KITTTITAS COUNTY COMMUNITY DEVELOPMENT SERVICES

Subject: Wenger (SPF-18-00005) Final Short Plat – Staff Review and 2nd Request for Additional Information

KITTITAS COUNTY		WASHINGTON	
DWN BY	DATE	JOB NO.	
S.W./G.W.	08/2018	06305	
CHKD BY	SCALE	SHEET	
M.K.K./S.W.	N/A	2 OF 3

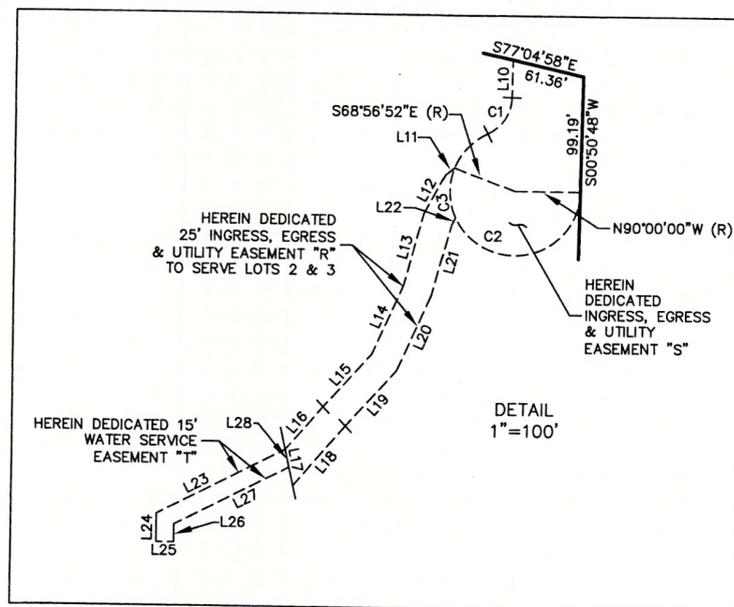
- 1) Condition of approval 7(d)(v) requires that the easement and driveway be shown serving parcel 616536. As submitted, the plat does not clearly depict access to parcel # 616536. There is an easement shown crossing the Wenger property, however, the easement is not labeled demonstrating it is for parcel # 616536. Please update either the plat note # 14 or the actual easement to indicate what parcel it serves.

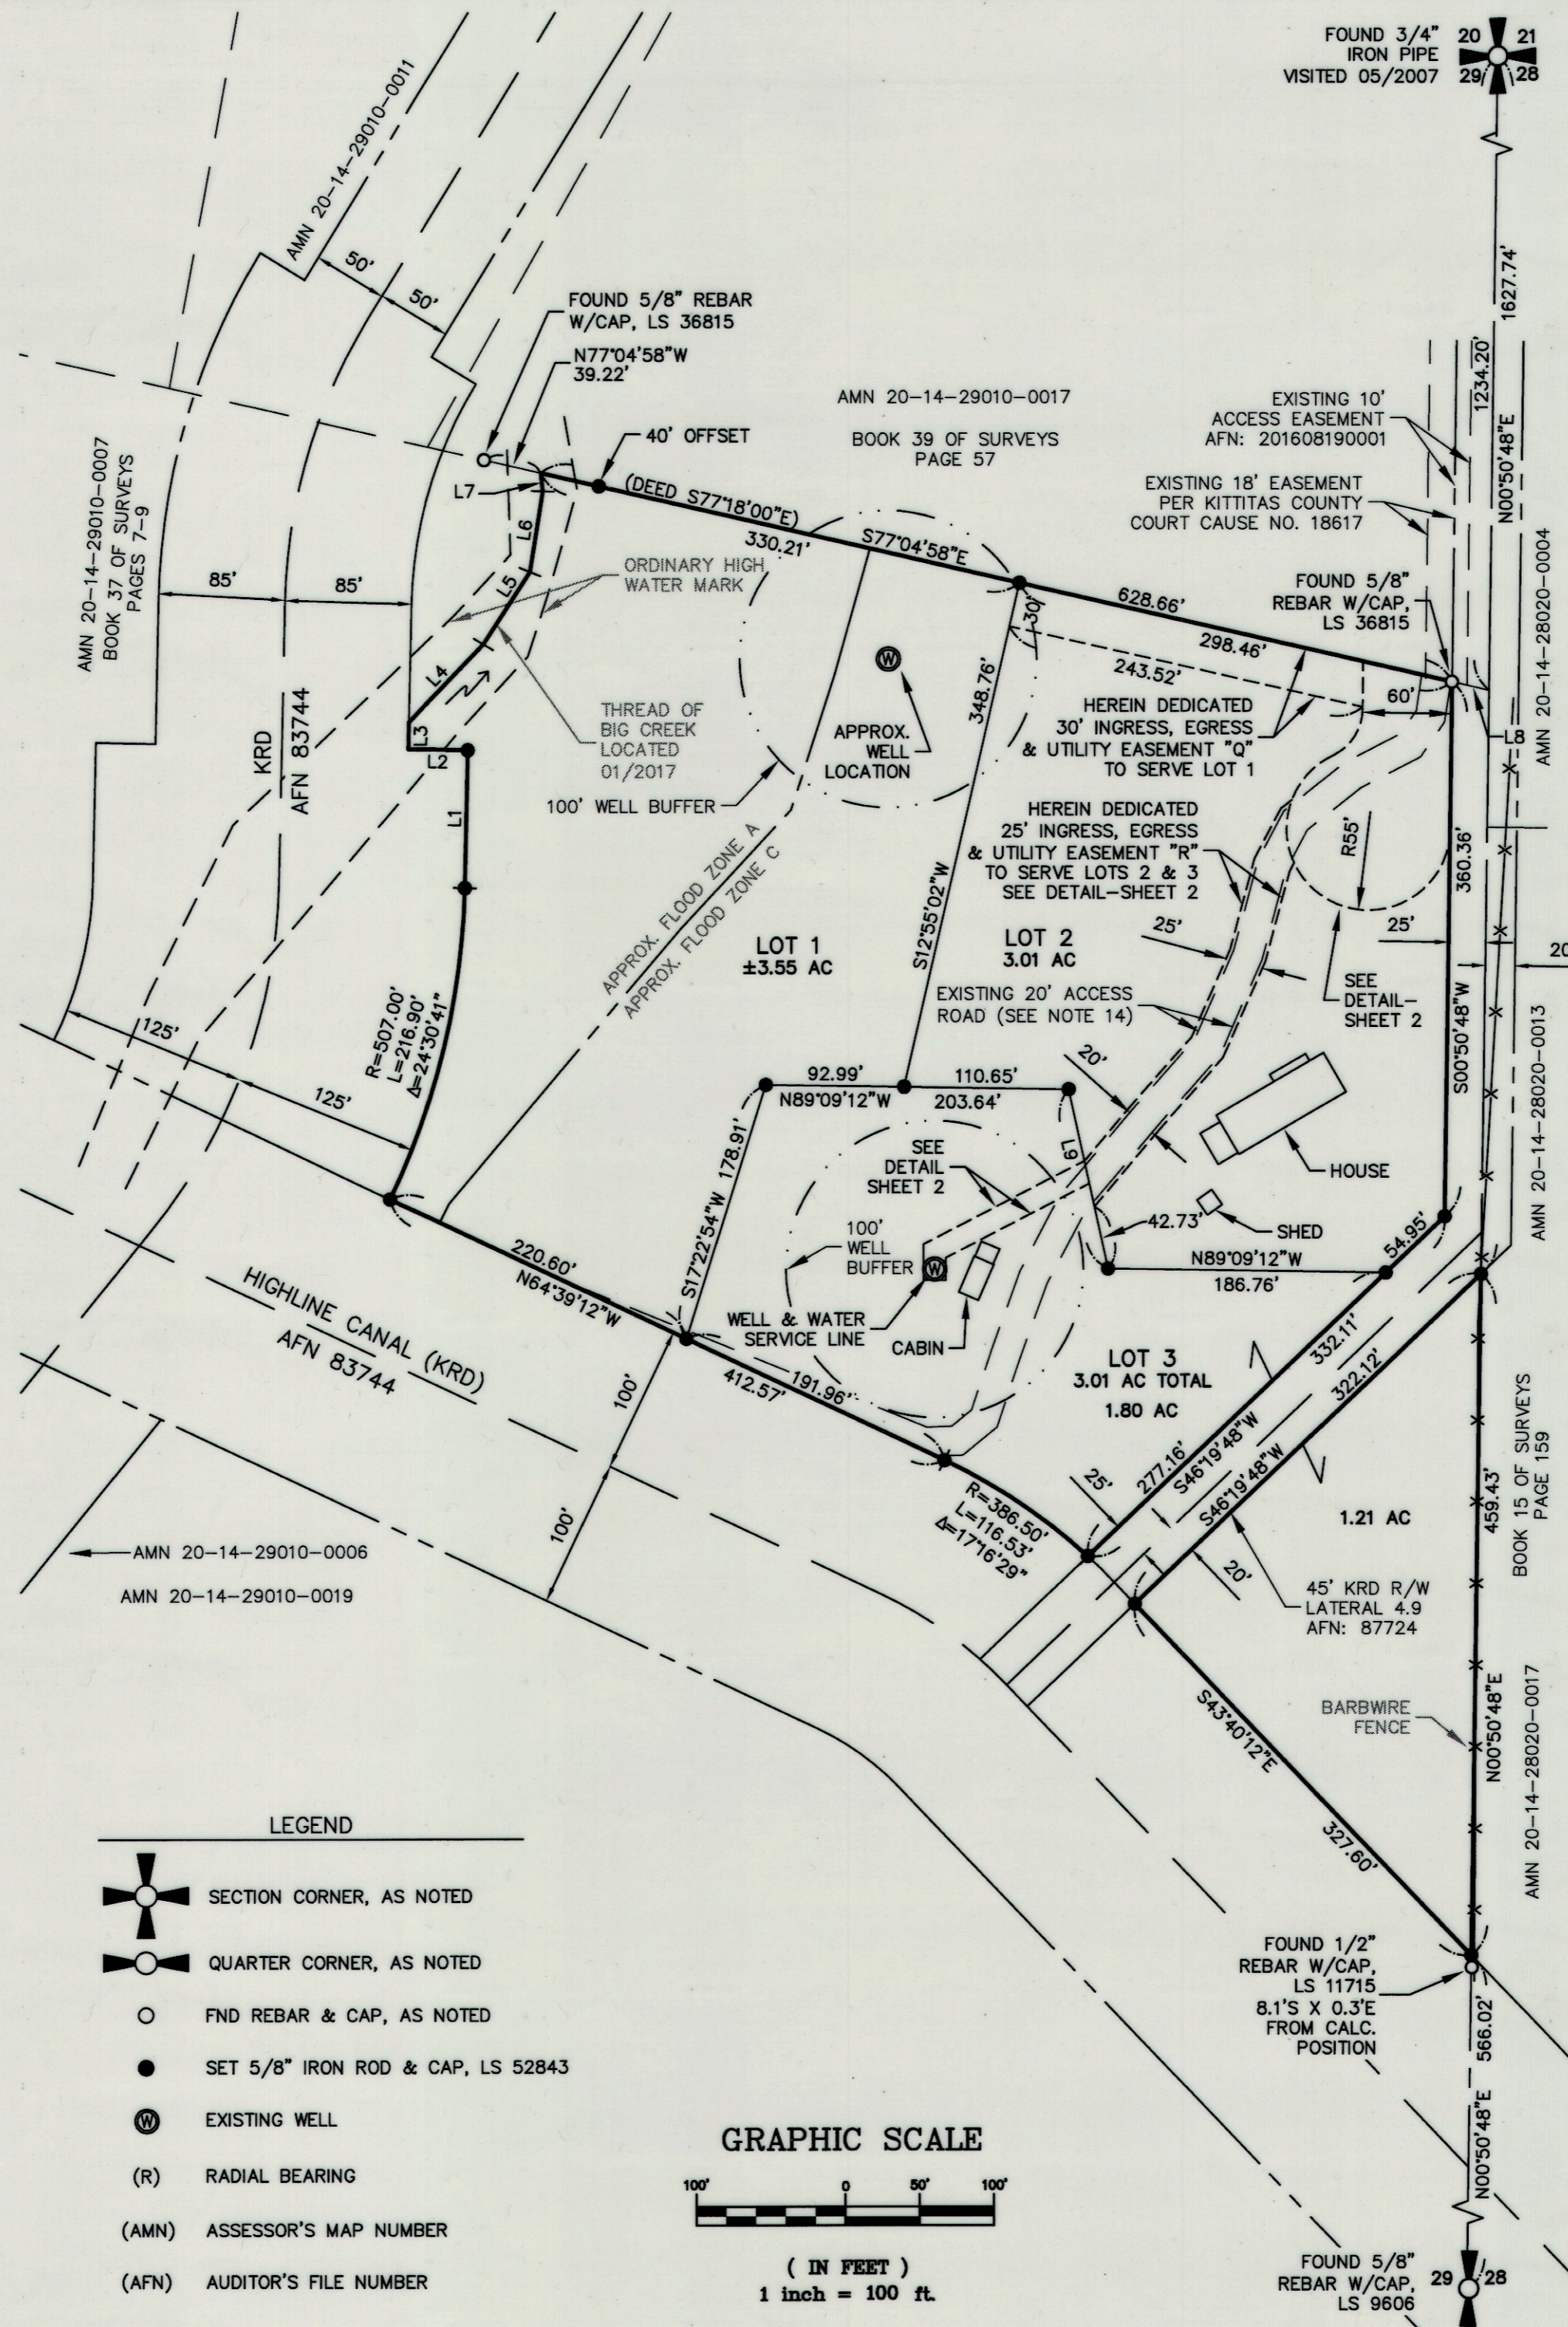
- 1) The shoreline jurisdiction has not been indicated on the face of the plat. If the 100 year floodplain and the 200' shoreline jurisdiction boundary are at the same line, it needs to be clearly labeled as such on the final plat, pursuant to condition 7(d)(ii) of the conditional approval for the Wenger Short Plat.
